Application ref: LU/366/19/DOC

Description: Approval of details reserved by condition imposed under ref LU/234/16/RES relating to Condition No 7 - acoustic barrier

Location: Fitzalan Link Road Littlehampton

The comments below solely respond to the landscaping associated with the latest drawing PHFL-WYG-S278-LP-FL1 Rev S.

Drawing Title:
PROPOSED S38/S278 HIGHWAY WORKS
FITZALAN LINK
LANDSCAPE PROPOSALS 1 OF 2

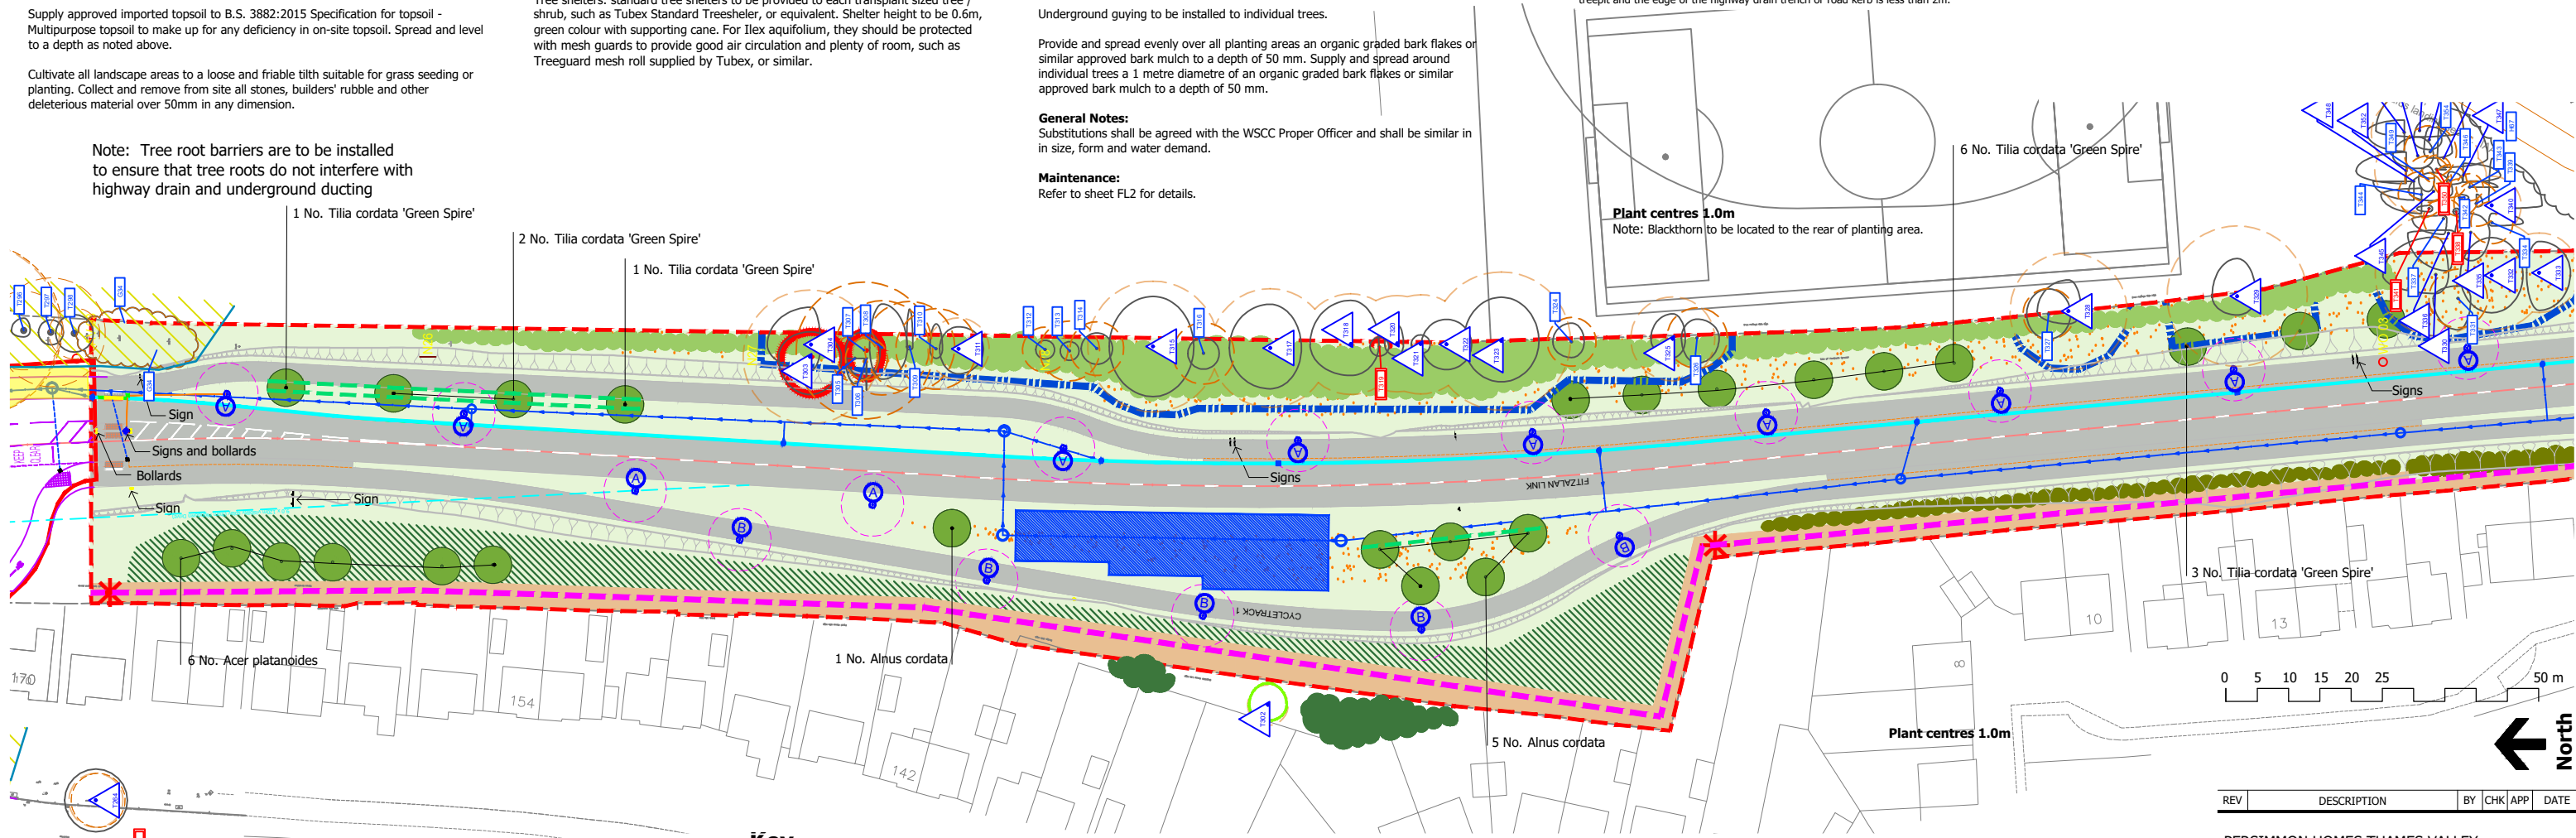
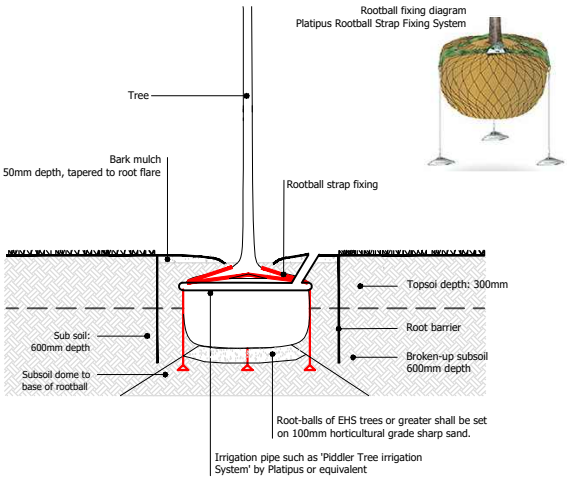
Drawings PHFL-WYG-S278-LP-FL1 1 & 2 of 2 Rev S contain a variation to planting mix with the addition of Native Planting Mix 3 and Native Planting Mix 4, which alongside the Native mix 1,2 & Native hedge remain suitable for location in species type, size and density proposed, however the quantities appear to have been reduced in quantity by approx 12% across the whole scheme. Amenity trees also reduced by approx. 10% from that previously approved.

I would therefore recommend justification is sought for the reduction in numbers to those previously approved.

Trees in close proximity to the proposed acoustic barrier will still require suitable growing medium and sufficient space to allow for these to establish and thrive. I would note caution if these are to be planted into banking or made up ground regarding the stability, free draining properties and the potential rain shadow effect of the fencing on these trees.

Landscape detail re species, densities and size suitable, recommend clarification is provided regarding plant numbers now proposed under revision S.
